Reference: #13S1213000

18 April 2016

**RE: 1 CARRINGTON STREET, SYDNEY
CARPARK ASSESSMENT FOR CC DOCUMENTATION**

CONCOURSE - CIRCULATION

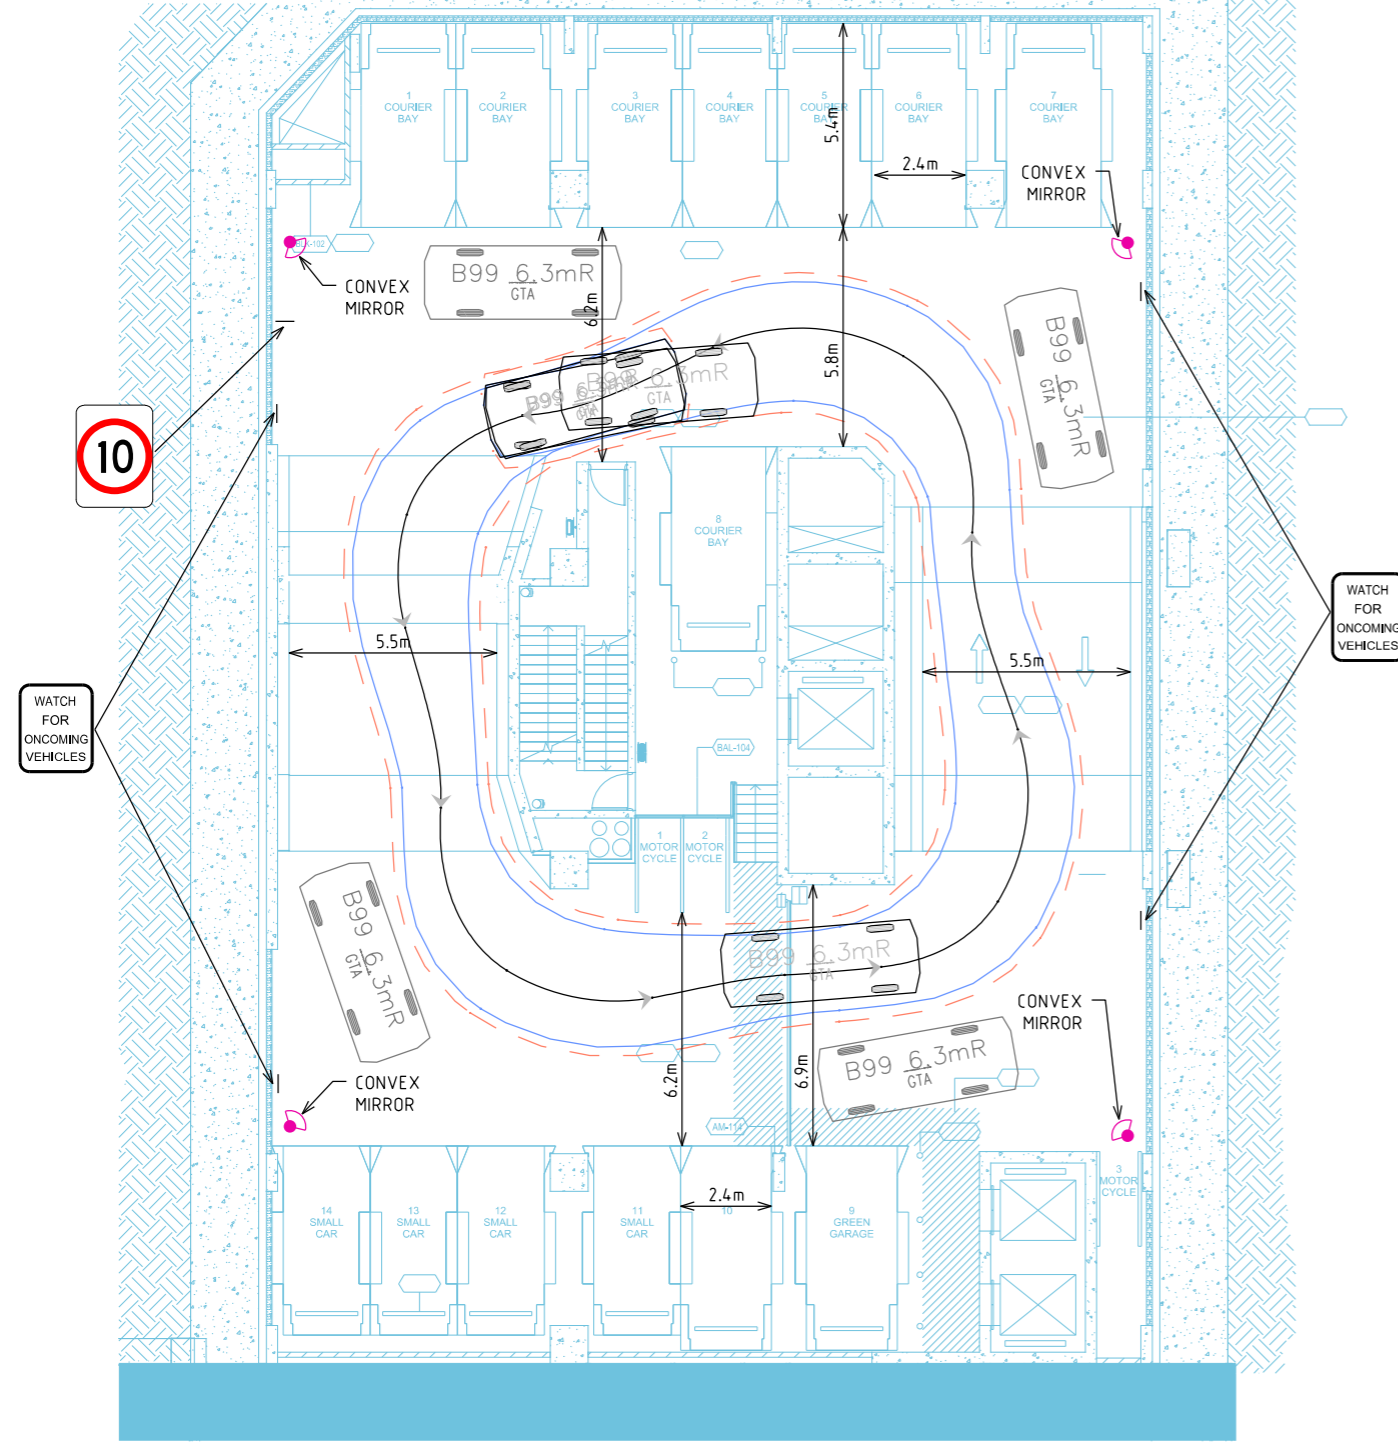
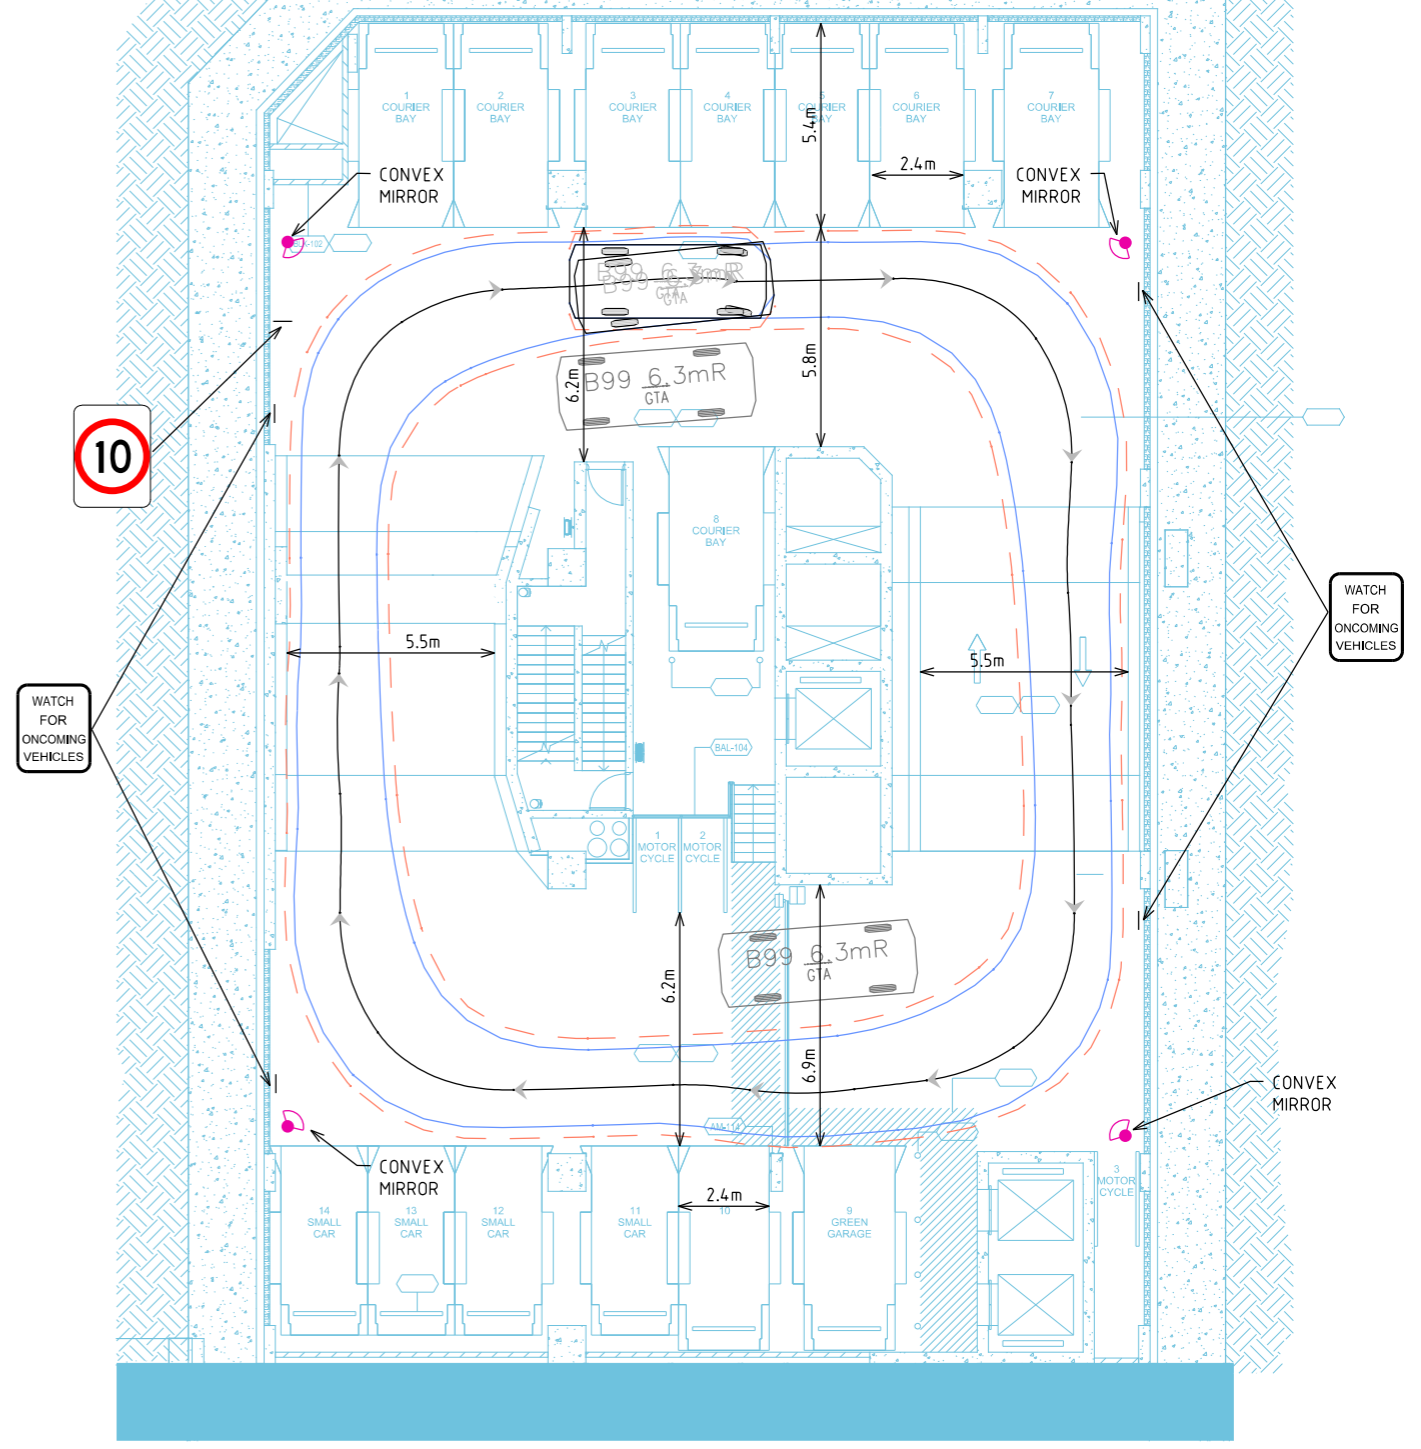
With respect to the car park within the Shell House Building, it is noted that the intersections between ramps and aisles do not accommodate the passing of a B99 and a B85, but rather simply a B99 to travel through the intersection and pass another nearby vehicle which would need to wait for the other vehicle to pass.

Albeit a technical non-compliance, the impact of two cars not being able to simultaneously pass each other is, in our view, minor, noting:

- The traffic volumes within the site are likely to be very low (for 89 car spaces within the basement, it is approximated that the car park would generate approximately 50 car movements in any peak hour).
- The probability of two vehicles needing to pass at any point within the car park, let alone one of the corners, is expected to be low given that the majority of cars will be entering and exiting the site during the AM and PM peak hour.
- The physical constraints of the site itself are such that it would be impractical to design for such an infrequent worst case scenario (noting that many building in such locations would feature this non-compliance)

In practice, the non-compliance is also unlikely to detrimentally impact the circulation of cars within the car park, or the safety of such movements, given that adequate space has been provided to allow cars to pass each other at suitable locations.

Moreover, it is also noted that this non-compliance was discussed at length within the GTA letter report (dated 9/11/15) submitted for the Section 96 Application, with swept paths from that letter presented below for reference. These swept paths show that vehicles will be able to pass each other at suitable locations near the internal intersections. GTA is not aware of any concerns with respect to this layout as submitted and approved but nevertheless note that the currently worded Consent Condition require a far more onerous design outcome.

In light of the identified issue, it is proposed that any conflicting vehicle movements, albeit minimum due to the unidirectional nature of their use, be managed via:

- i At the entry point to the Shell House Building carpark, entering vehicles are informed by signage to:
 - I. turn on head lights
 - II. give way to exiting vehicles
 - III. proceed down the ramp slowly
- ii Once circulating within the carpark ramps, entering vehicles have right of way over exiting vehicles. In the unlikely event that a conflicting (entering) vehicle approaches the ramp, an exiting vehicle is to manoeuvre into a position to enable the other vehicle to pass. These locations are shown in Figure 1,
- iii The provision of other signage and convex mirrors as shown in Figure 1.
